Sent: 09 November 2018 11:49
To: Simon Davis; Planning Scanning
Subject: RE: Planning Consultation on: AL/57/18/OUT

We have included in our submission a drawing 1423-P-103 Block Plan which shades all of the current buildings, existing and proposed, in dark grey. We have hoped to illustrate here that the proposed detached buildings and space separation is similar to the layout pattern of neighbouring buildings. The consultant's proposed layout shows terraces which are not found within this setting.

Dwg No. **1428-P-125 Rev A**

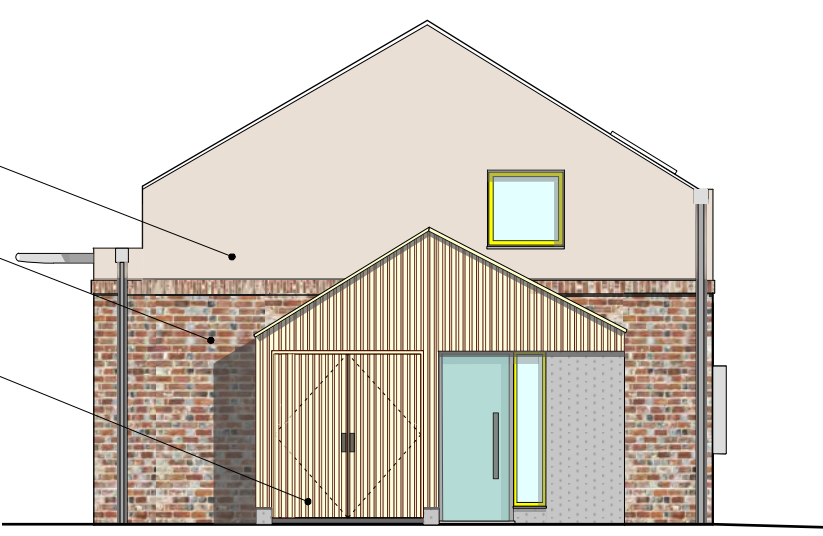
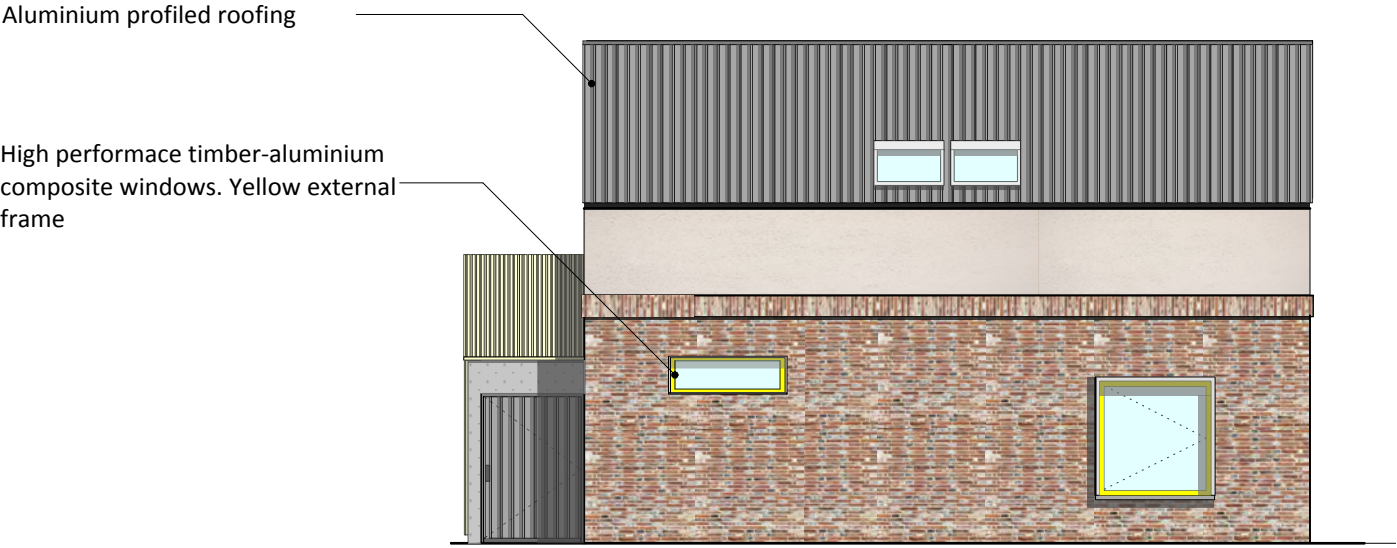
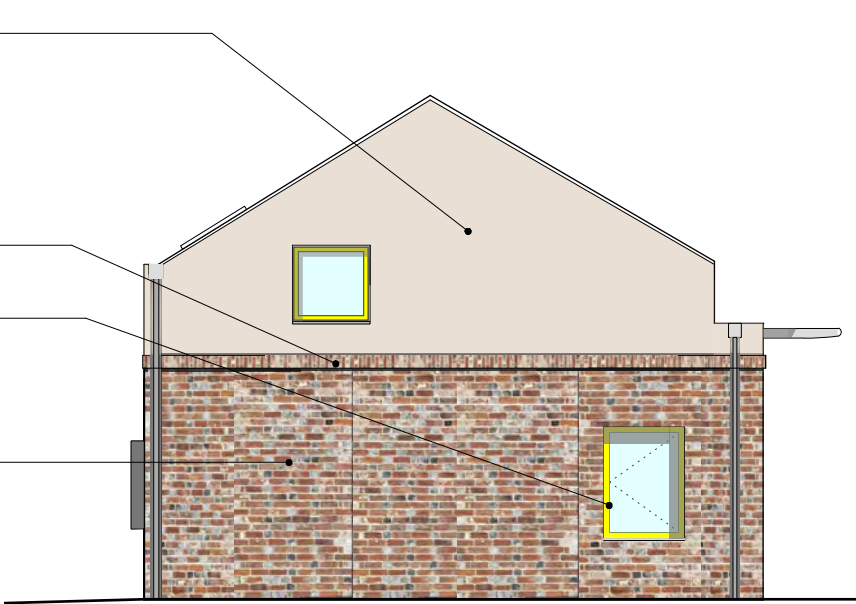
Additionally, given the core intent for maximising solar gain/ minimising heat loss, it was also noted that there is limited variation between the current north and south elevations of the apartments.

It is understood that materials have been selected to support Passivhaus qualities. However, at present, it is unclear how these relate to a local context - this is significant to ensure that new development will become well integrated with the existing community rather than a self contained entity.

Dwg No. 1428-P-102 RevA

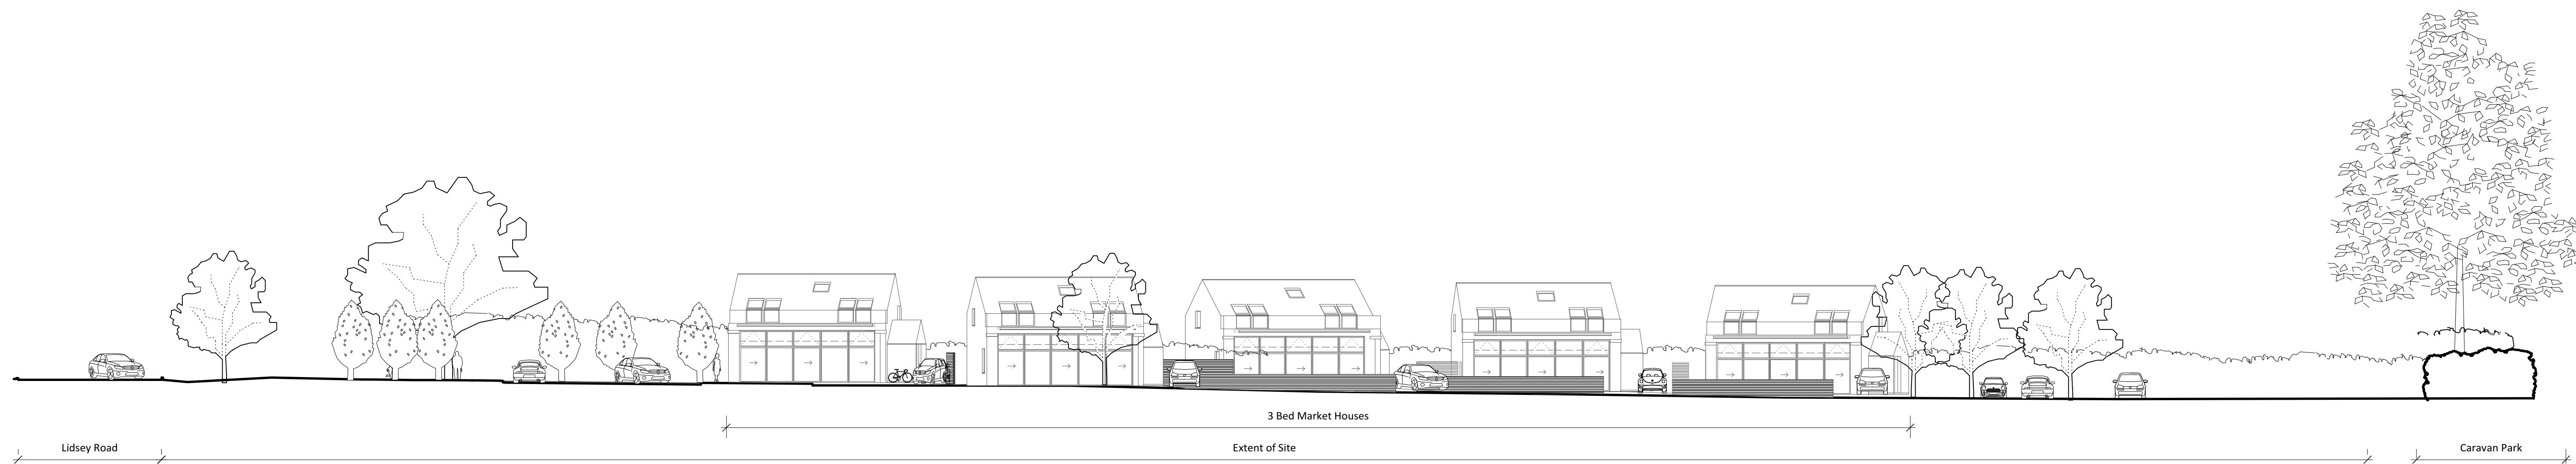
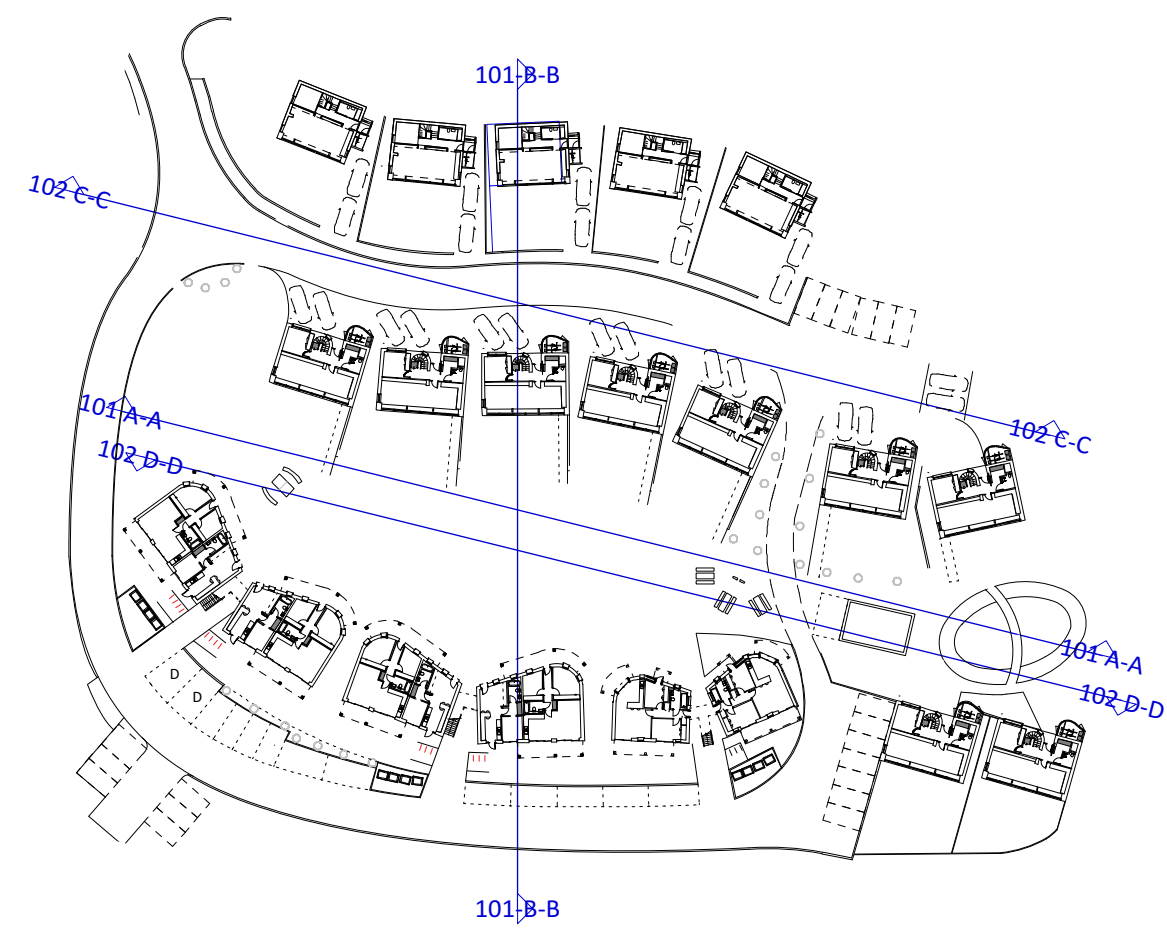
We have devised an original cross section through the house types to permit greater penetration of sunlight into the depth of the plan. In all accommodation we have sought to link open plan living areas to the south facades so that we achieve maximum benefit from passive solar gains.
